**Re: Sawmill Crossing Unit 1, Grading Certification**  
**Engineer's Stamp dated: 11-8-13, (H13D057)**  
**Certification dated: 1-31-14**

Based upon the information provided in the Certification received 1-31-14, the above referenced certification is not acceptable for Final Plat or Building Permit approval for the following reasons:

TITLE: **SAWMILL CROSSING - UNIT 1**
REVISED GRADING & DRAINAGE PLAN

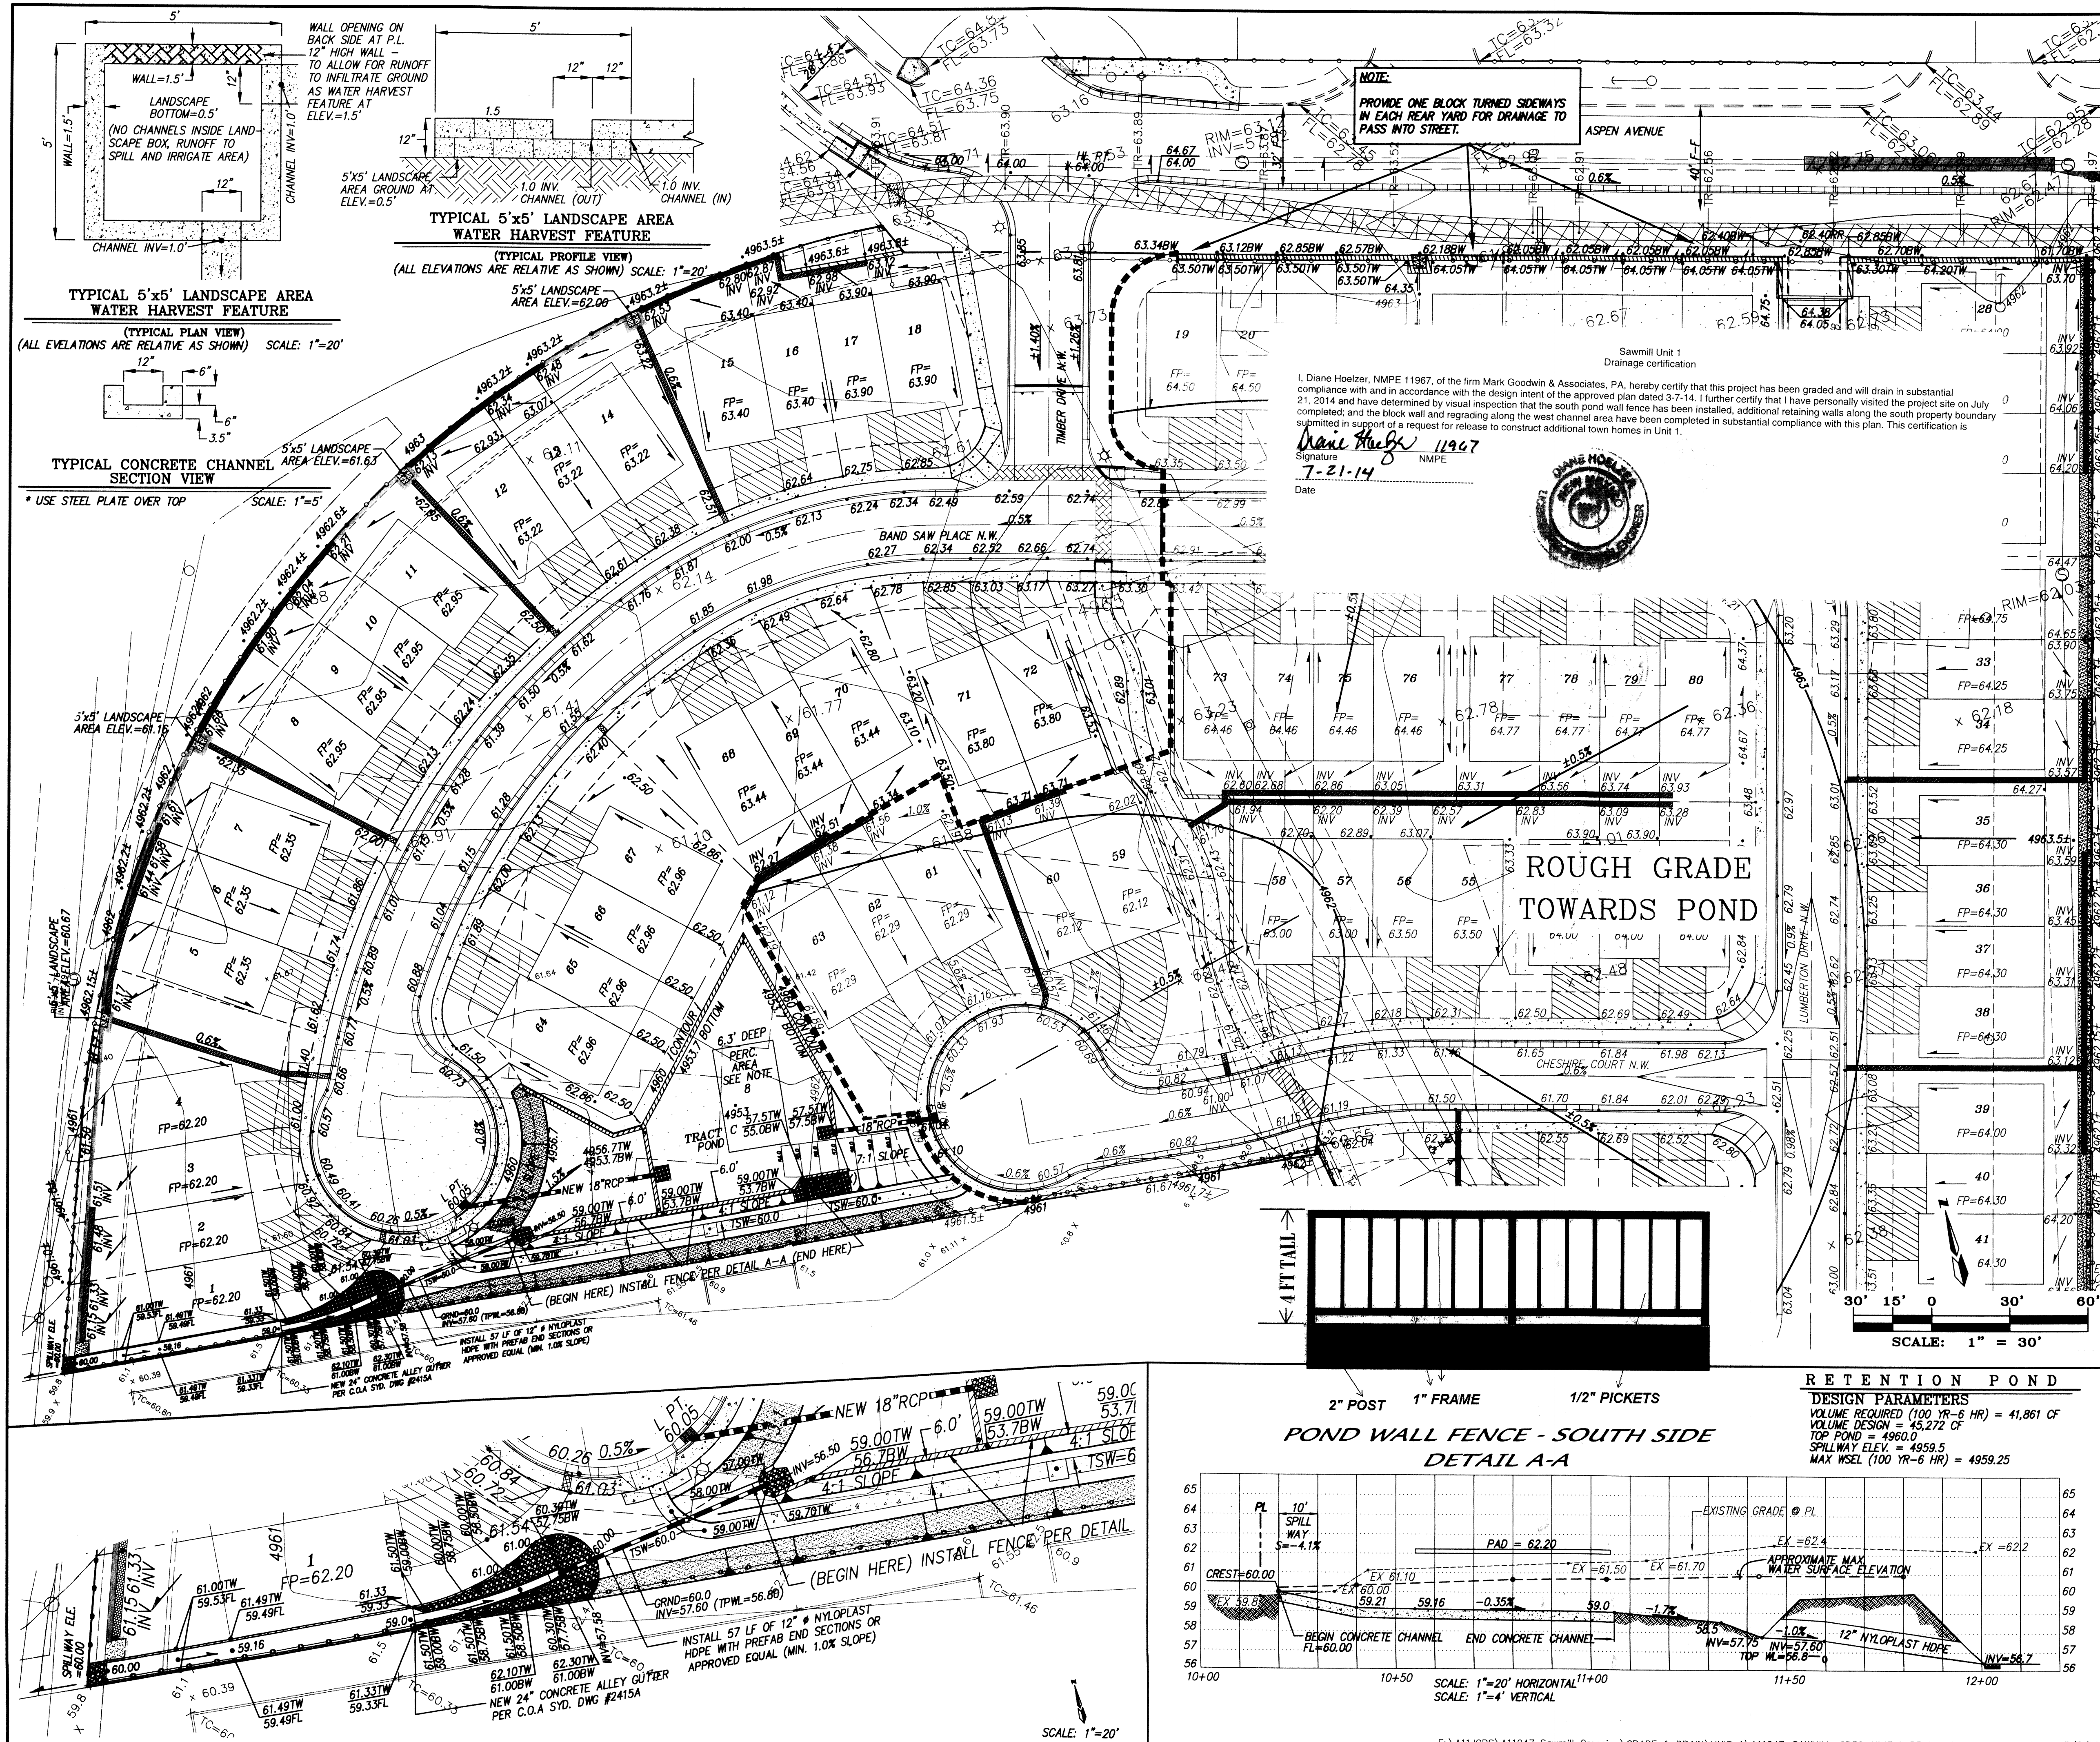
1. The location of the Comcast box on Lots 14/15 will not allow the construction of the channel. Hydrology recommends relocating the Comcast box.
2. The 5 foot square landscape areas are completely wall-in. It is not clear that the home builder will be able to construct the channels per the approved plan. The block(s) should be removed at the approved invert and this grade surveyed and certified.

3. Grading in the area of the rear and side yard channels is not complete. How will the builder be able to build the channels at the proper elevations?

4. The infrastructure list states that all perimeter walls will be constructed. There is a 10 foot section missing along the back of Lot 5.
5. The earth should be stabilized from the east end of the concrete channel to the top of the slope at the pipe entrance. In addition, the header curbs should be supported. Hydrology staff met with Ms. Hoelzer and recommended that the side slopes could be concrete and tied into the header wall and alley gutter. Ms. Hoelzer was to propose a solution.

6. Where the 12" pipe daylights in the pond there is an earthen slope approximately 4 feet high at a 1:1. Should a retaining wall be built?
7. East of the retaining wall on the south side of the pond there is an approximate 5 foot high slope at a 1:1. A retaining wall should be constructed to the point where the slope is at a 3:1 maximum.

8. If the side and rear yard channels are not to be constructed until Building Permit, add a note to the certification that states that the channels are "not built" and they are to be constructed with the Building Permit.

- a. The rear and side yard channels are to be constructed with the first building in each pod (e.g Lot 5, 6 and 7).

- b. A copy of this plan shall be included in the Building Permit set.
- c. This grading plan is to be certified for release of Certificate of Occupancy.
- d. A swale was graded in the proximity of the concrete channels. This should be added to the certification.
